Re: Palomas Peak Ph. 2 Office Development/ 8300 Palomas Ave. NE
Request for Certificate of Occupancy
Transportation Development Final Inspection
Engineer's Stamp dated 2-12-21(D19-D031)
Certification dated 3-30-22

April 7, 2022
Project: Palomas Peak, 8300 Palomas Ave NE
Subject: TCL Certification for D19D031
30-Day Temporary Certificate of Occupancy

SITE PLAN

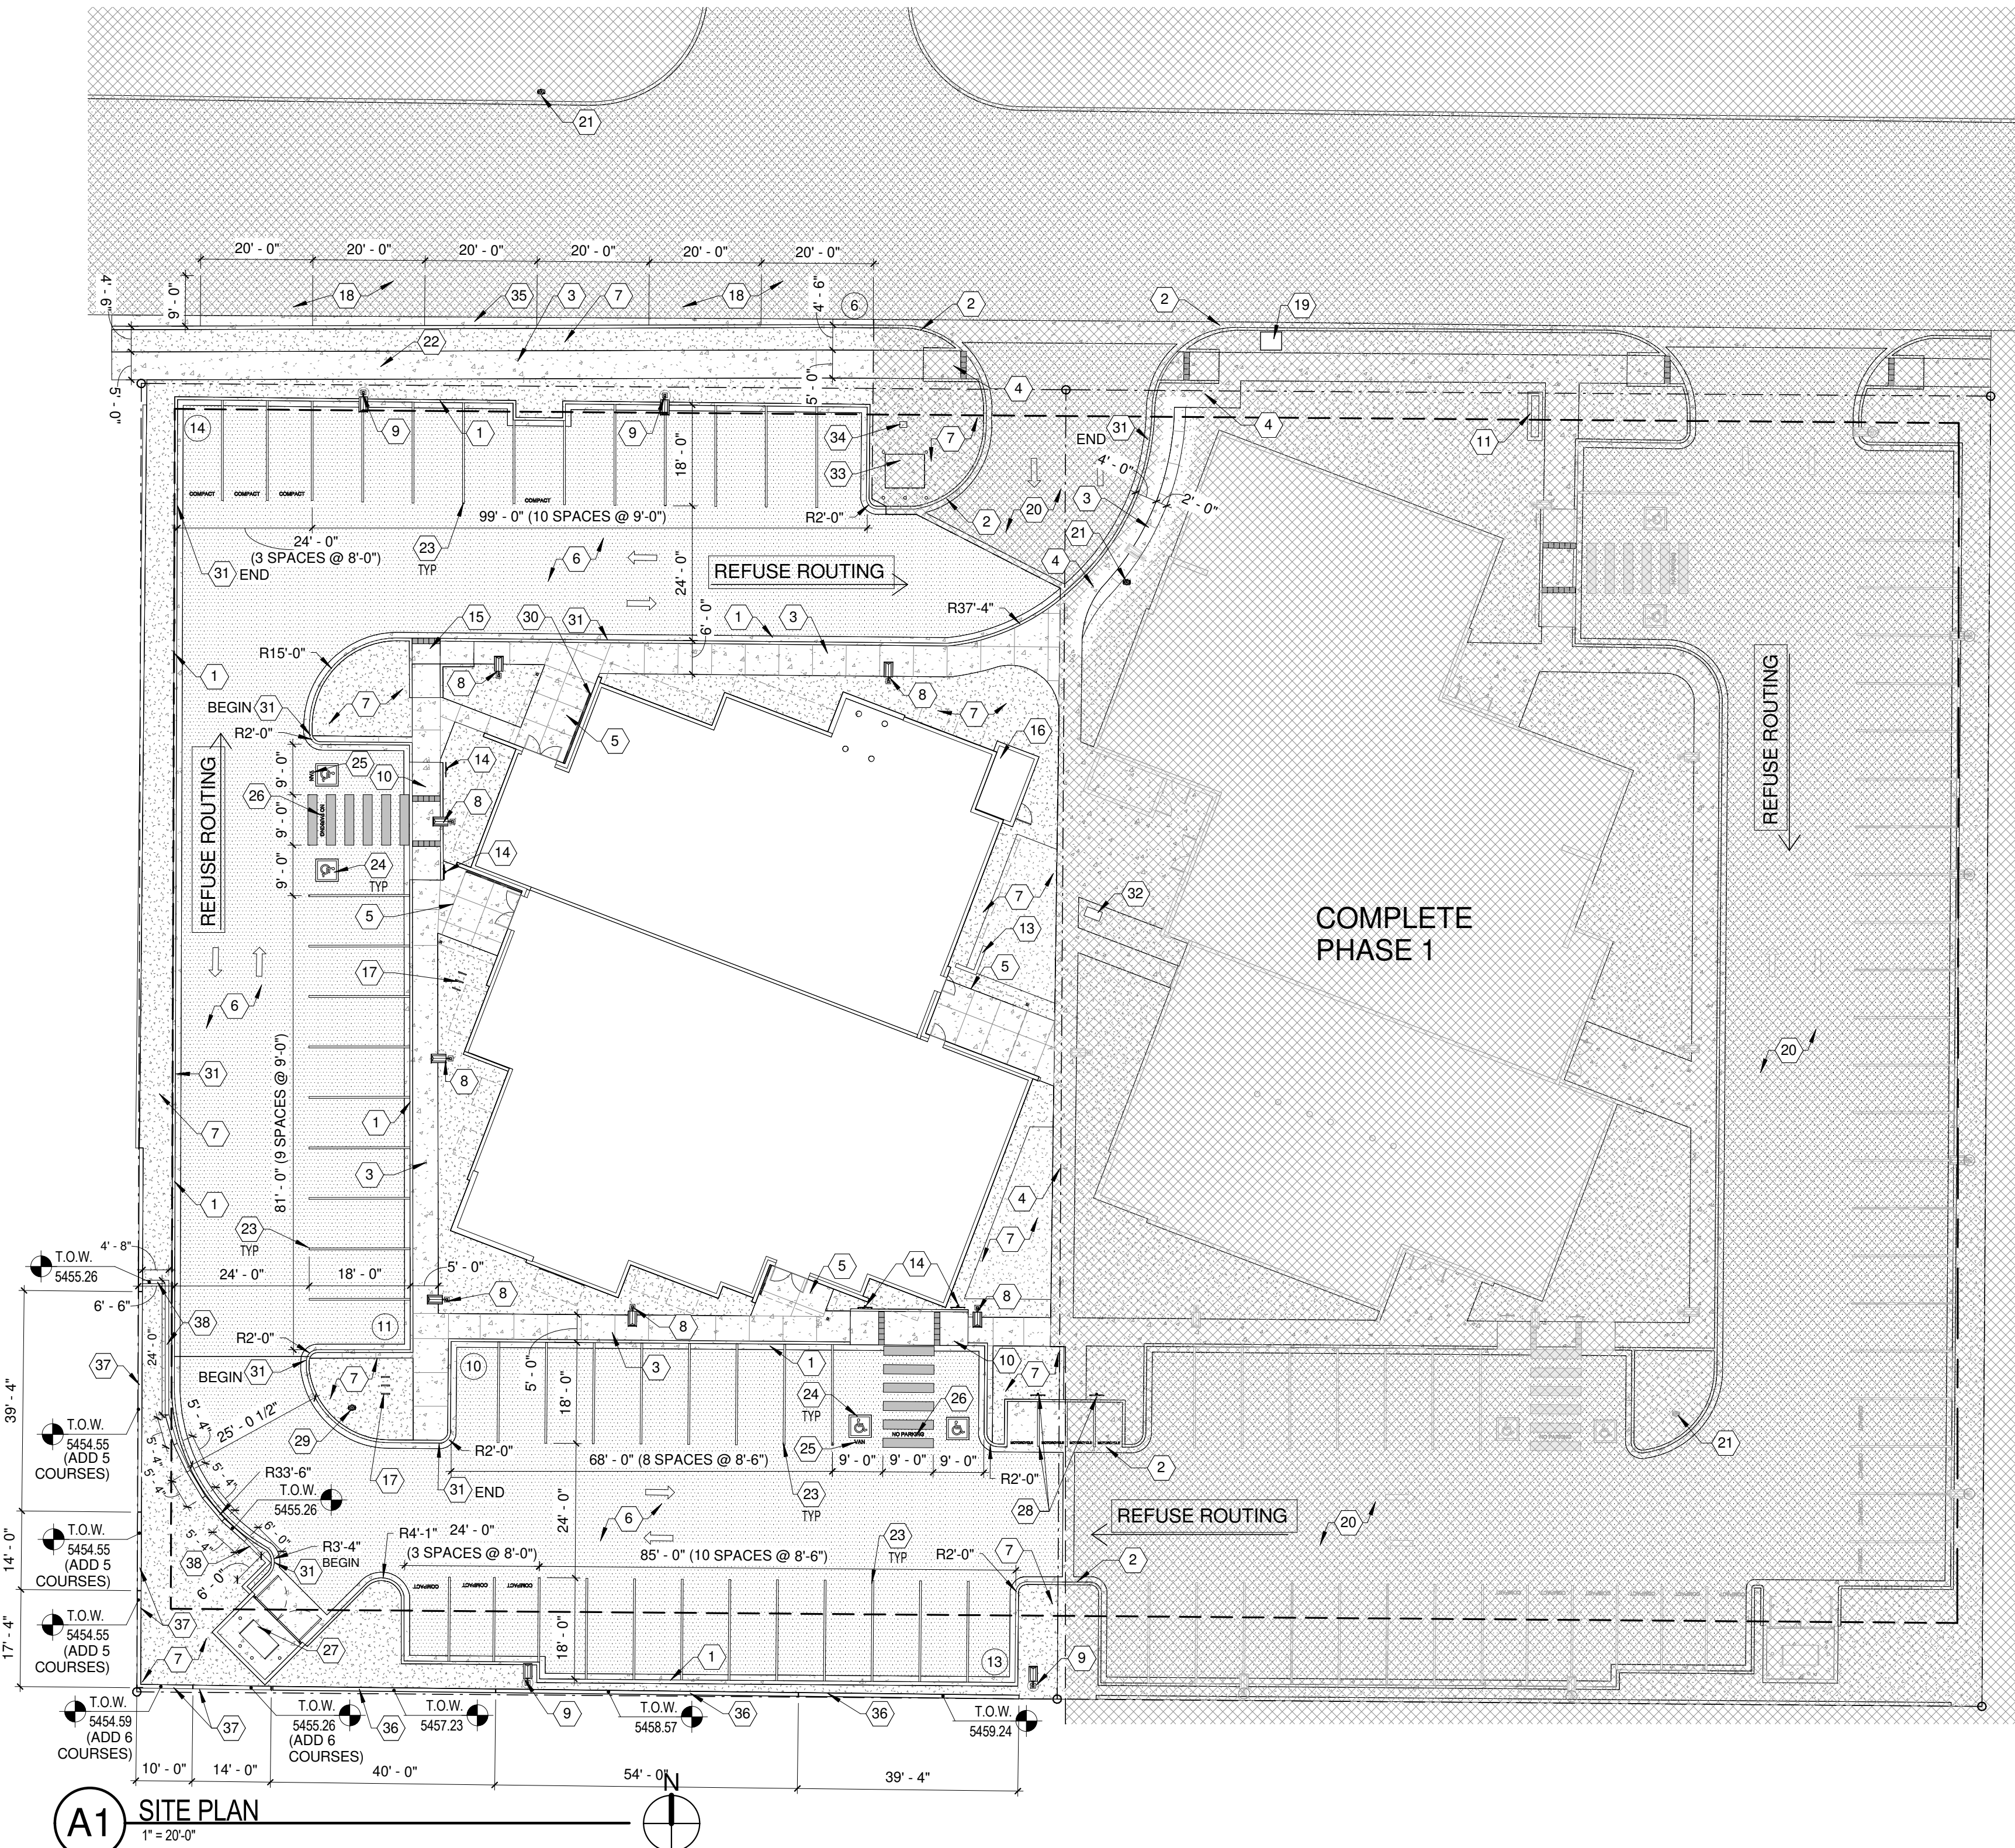
- There is a new ramp on the north side of the building, please red mark the approved TCL (add a key note for this ramp).

- Paint the curb that located at the northeast side of the driveway entrance with yellow. Just the segment that parallel with the ADA ramp, for tripping hazard issue.

- Please see attached revised site plan with ramp indicated and clouded on the north side of the building.

- Please see images below of curb segment painted bright yellow.
